KITTITAS COUNTY

MEMORANDUM

SUBJECT: Blue Sky Short Plat SP-10-00003

BLUE SKY SHORT PLAT
A PORTION OF THE SOUTH 1/2 OF SEC. 29 T.20N., R.16E., W.M.
KITITAS COUNTY, WASHINGTON

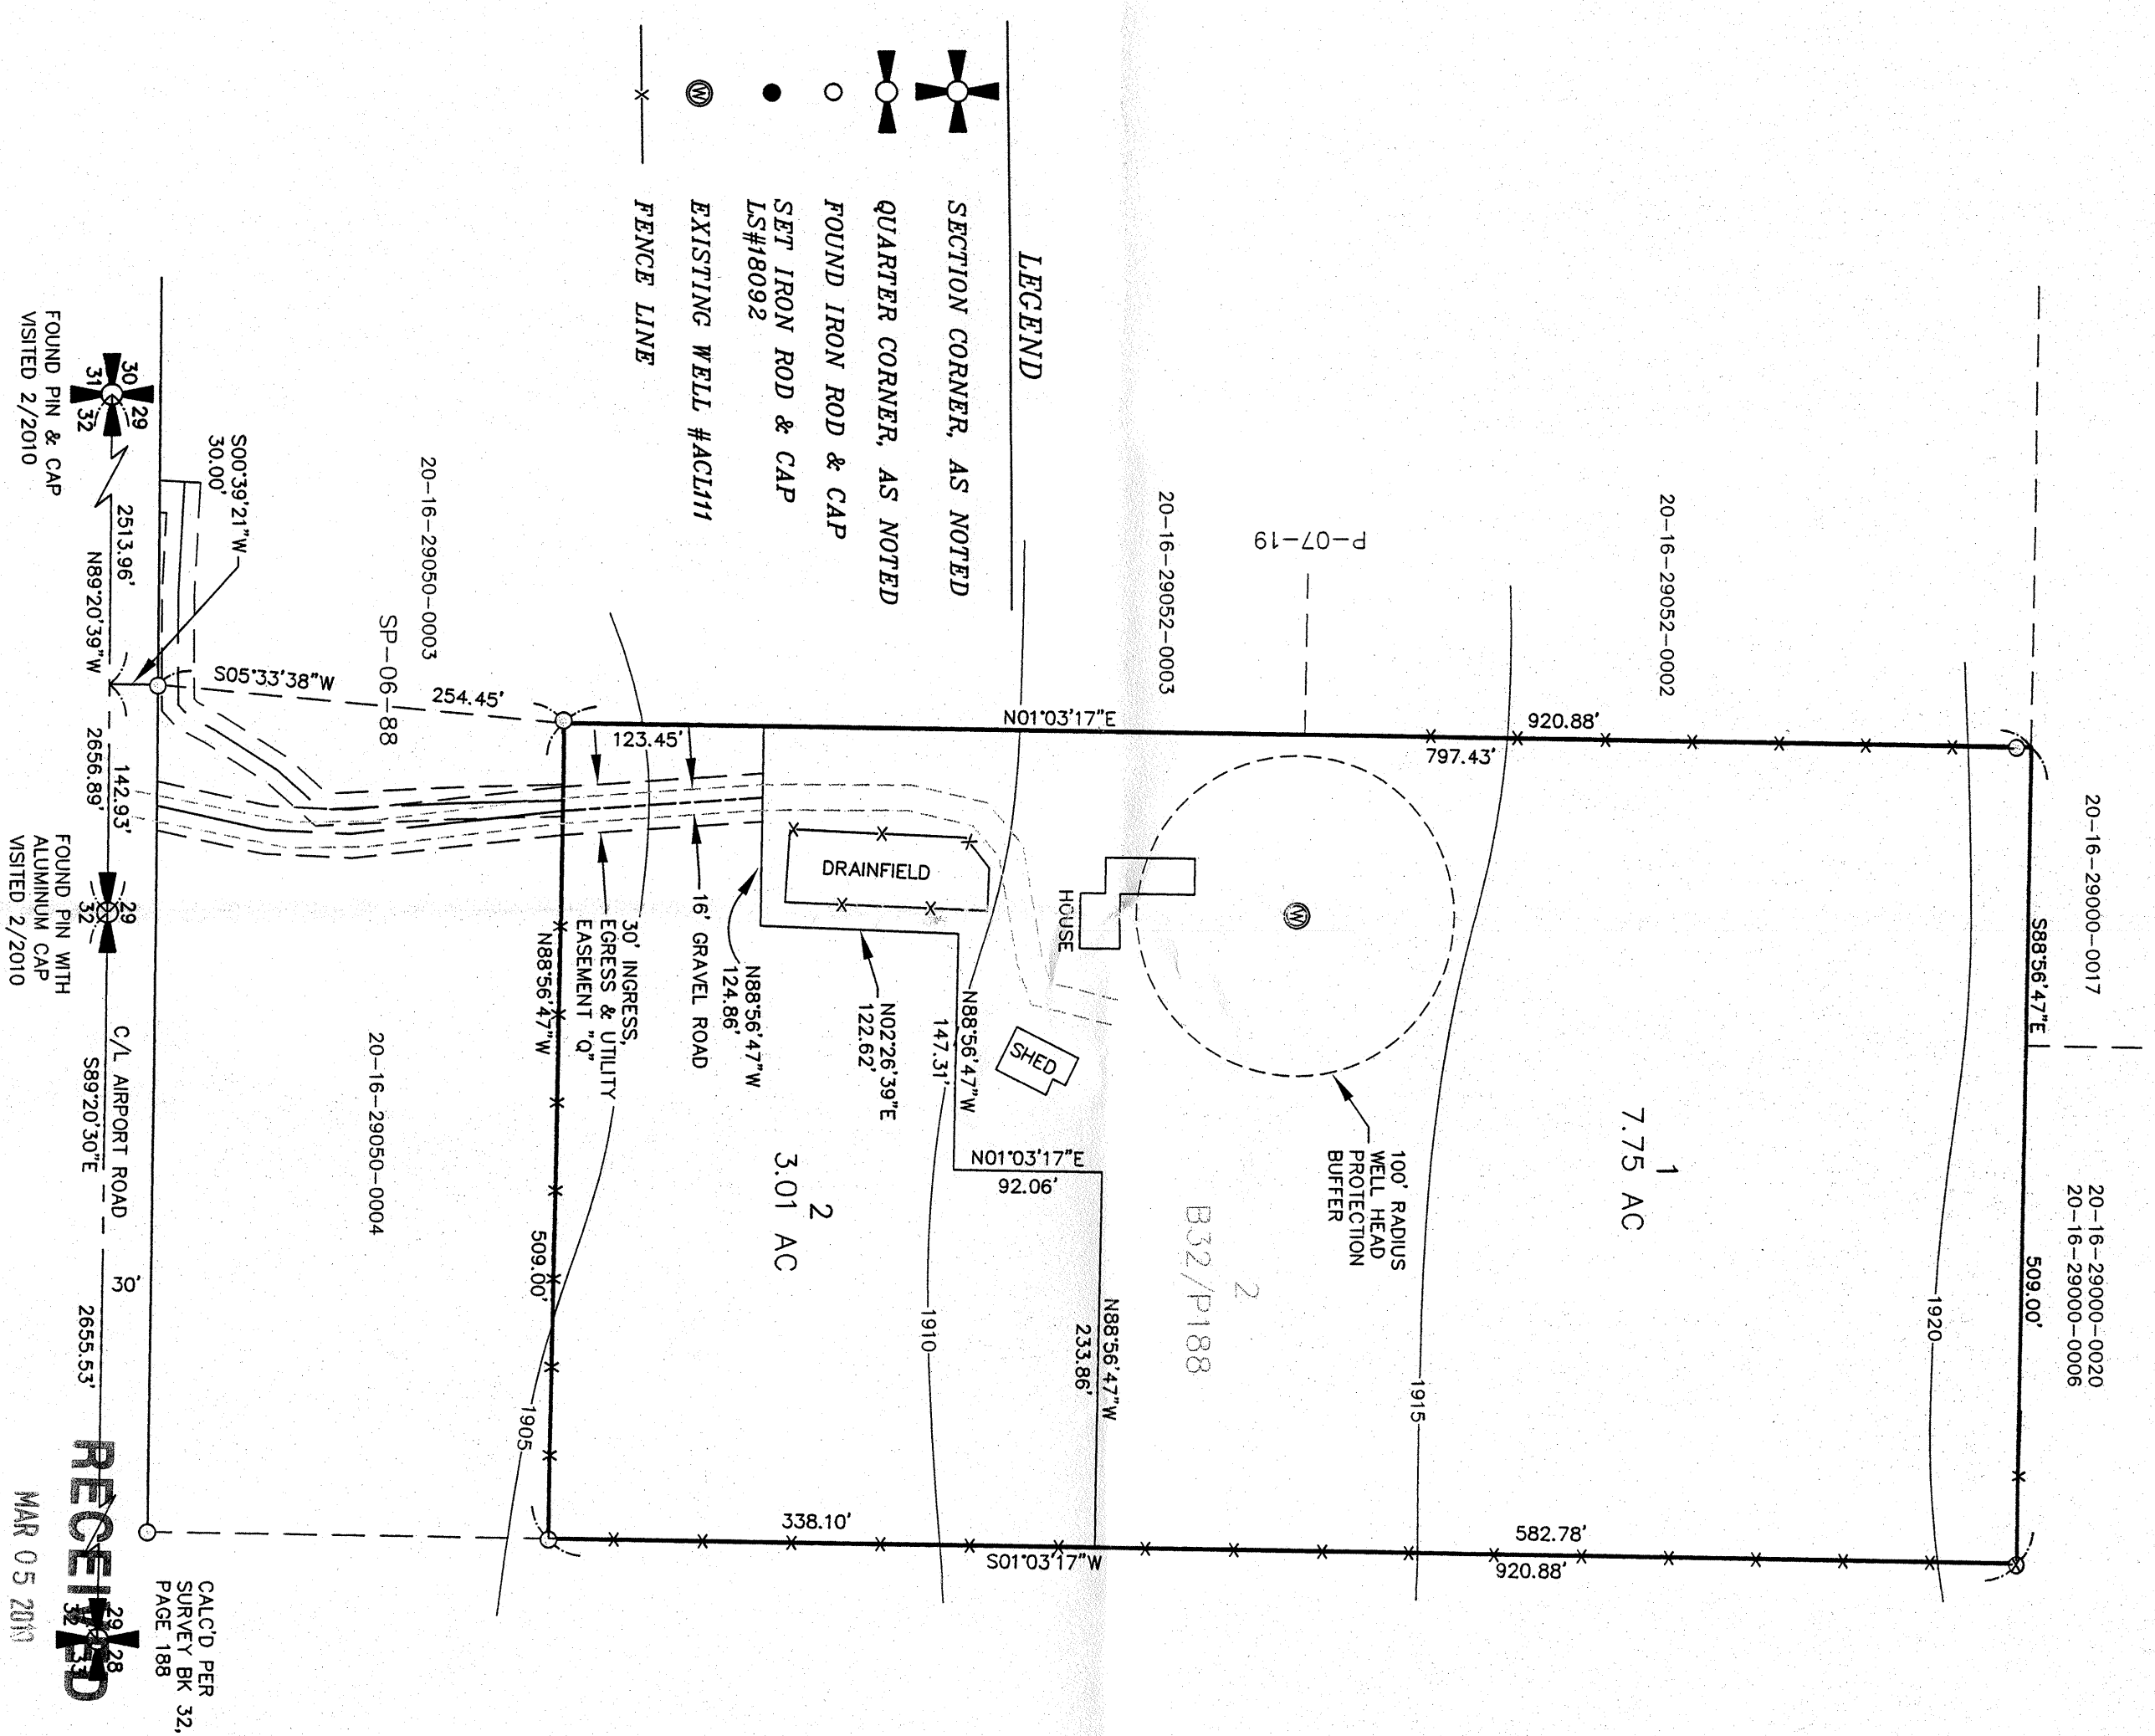
4. Private Road Improvements: Access from Airport Road to the cul-de-sac shall be constructed to meet or exceed the requirements of a High-Density Private Road that serves 3-14 tax parcels. See Kittitas County Road Standards, 9/6/05 edition.

- a. Access easements shall be a minimum of 40' wide. The roadway shall have a minimum width of 20', with 1' shoulders, for a total width of 22'.
 - b. Minimum centerline radius will be 60'.

- c. Surface requirement is for a minimum gravel surface depth of 6".
 - d. Maximum grade 8% flat, 12% rolling or mountainous.
 - e. Stopping site distance, reference AASHTO.

- j. All easements shall provide for AASHTO radius at the intersection with a county road.
 - k. A paved apron shall be constructed at the intersection of the proposed private intersection and the county road.

5. Cul-de-Sac: A cul-de-sac turn-around having an outside right-of-way or easement diameter of at least 110 feet shall be constructed at the closed end of all dead-end roads serving 3 or more lots. The driving surface shall be at least 96 feet in diameter. Cul-de-sacs must also conform to the requirements specified by the 2006 International Fire Code. Contact the Fire Marshal regarding any additional cul-de-sac requirements.
